# CITY OF ALBUQUERQUE

July 22, 2021

**Re: McMahon Shopping Center  
McMahon/Unser NW  
Traffic Circulation Layout  
Architect's Stamp 07-20-2021(A11-  
D017B)**

UNSER & MCMAHON  
ENLARGED SITE PLAN  
ALBUQUERQUE, NM  
PROJECT #2063

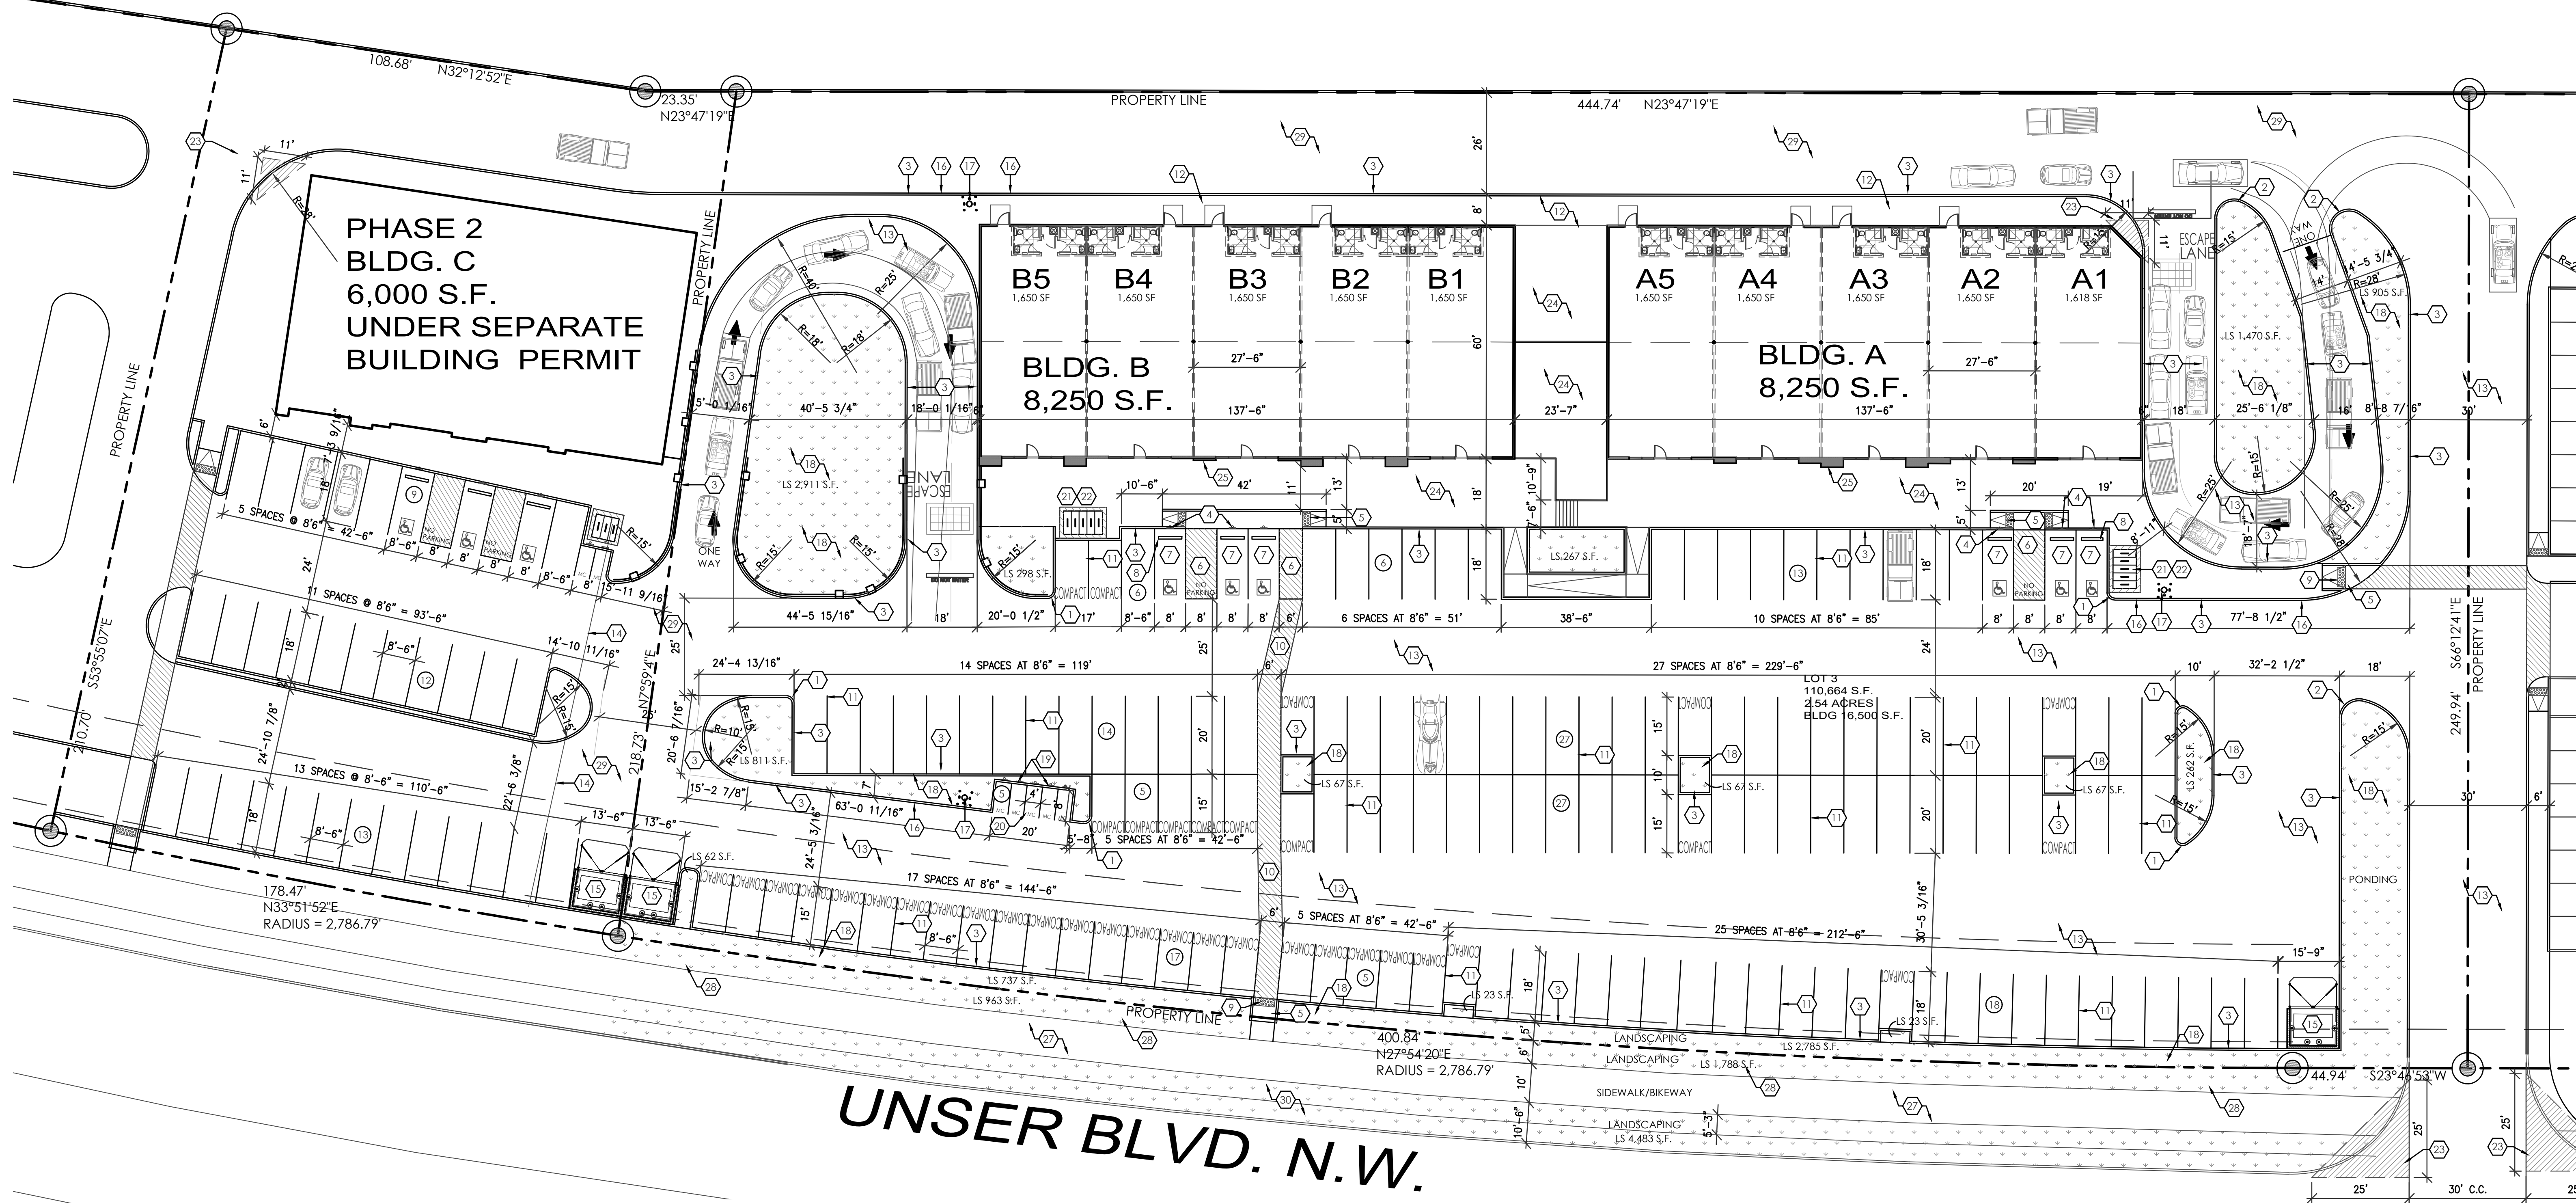
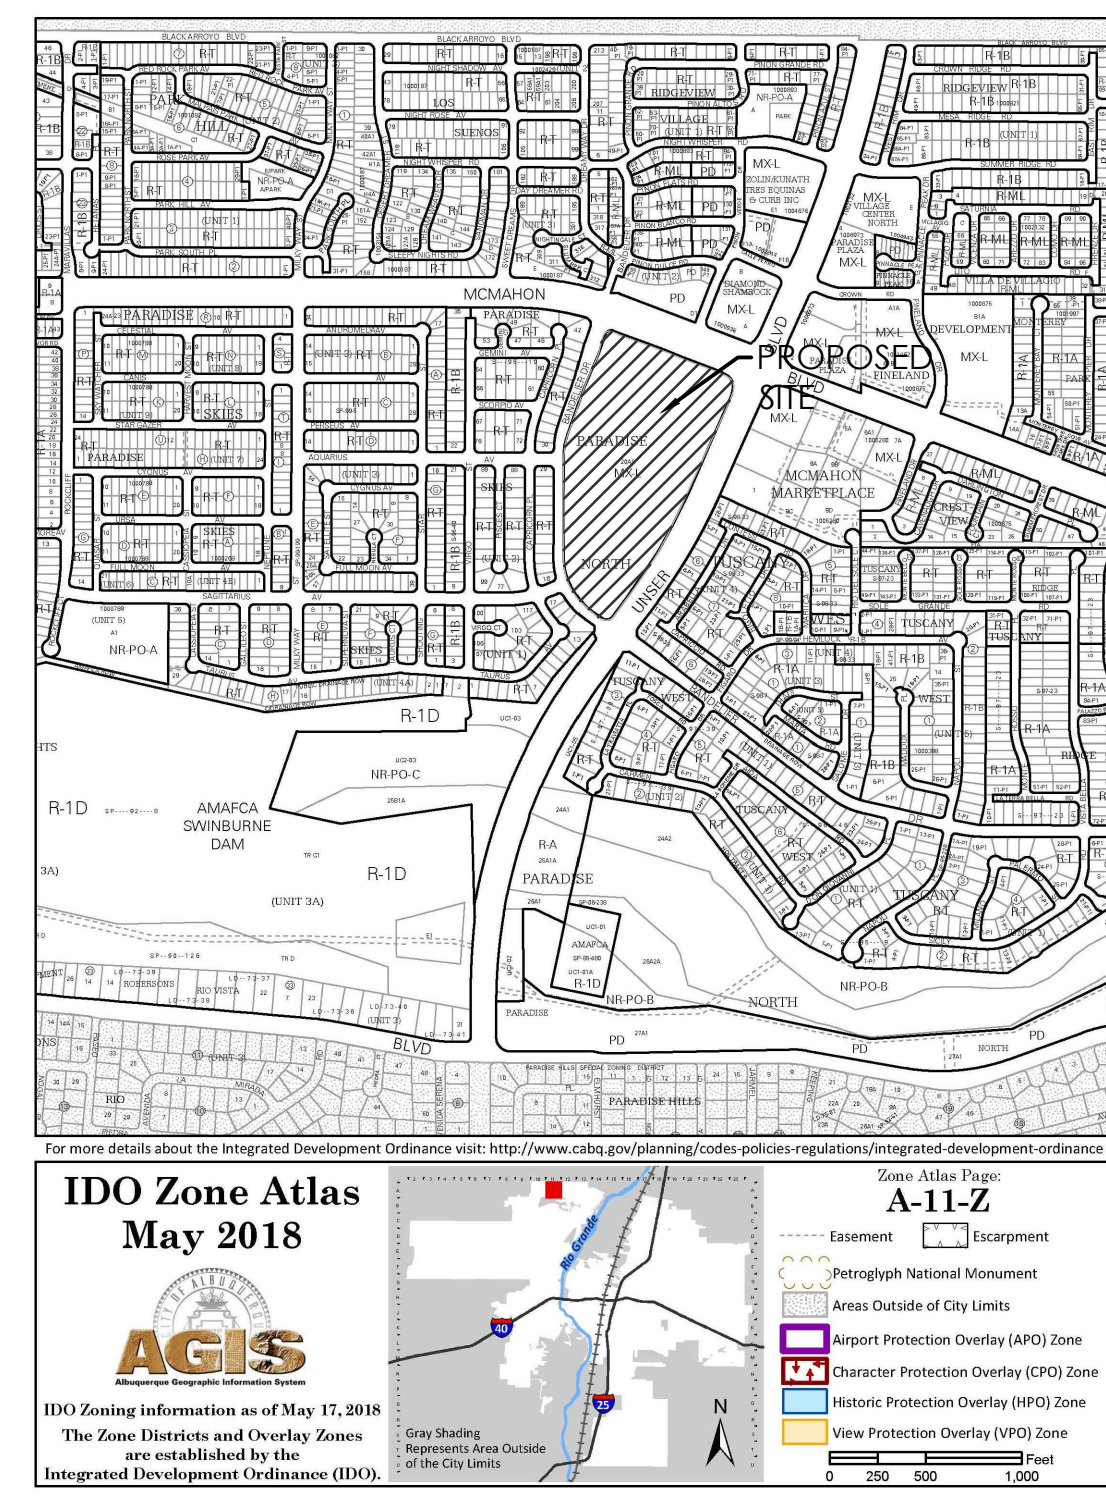
3. **Another access entrance/point is need to provide emergency accommodation for ingress/egress.**
4. How will you service the Main Circulation Road behind buildings A & B: **You show how a vehicle encroaches into the drive thru lanes which is a safety concern. Please address these concerns.**

- Show how the proposed entrance lines up across Unser existing development on the eastern side.
  - Label all existing infrastructure on Unser.
7. Provide end treatments/construction notes/details for adjacent properties that will not be part of this submittal. So, 22 ft of two way traffic is needed for circulation around the parameter of the proposed development.

8. Identify all existing access easements and rights of way width dimensions.
9. **Identify the right of way width, medians, curb cuts, and street widths on Unser Blvd NW.**

10. Please list the width and length for all proposed parking spaces. **Some dimensions are not shown.**
11. The minimum parking stall dimensions are:

12. **ADA curb ramps must be updated to current standards and have truncated domes installed.**
13. Motorcycle parking spaces shall be designated by its own conspicuously posted upright sign, either free-standing or wall mounted per the zoning code. Label pavement MC.

18. List radii for all curves shown; for passenger vehicles. **Radius for delivery trucks, fire trucks, etc. is 25 ft. or larger.**
19. Per the IDO, **a 6 ft. wide ADA accessible pedestrian pathway is required from the public sidewalk to the building entrances.** Please clearly show this pathway and provide details.

21. **ADA 6ft wide Pedestrian continuity needs to be provided between buildings A & B**
22. The proposed ADA parking stall:
  - **Ramp are only 5 ft width. 6ft is the requirement.**

- **The back of ramps are a safety concern (tripping hazard) for pedestrians.**
23. **Unser pathway: Provide widths of existing pathway.**
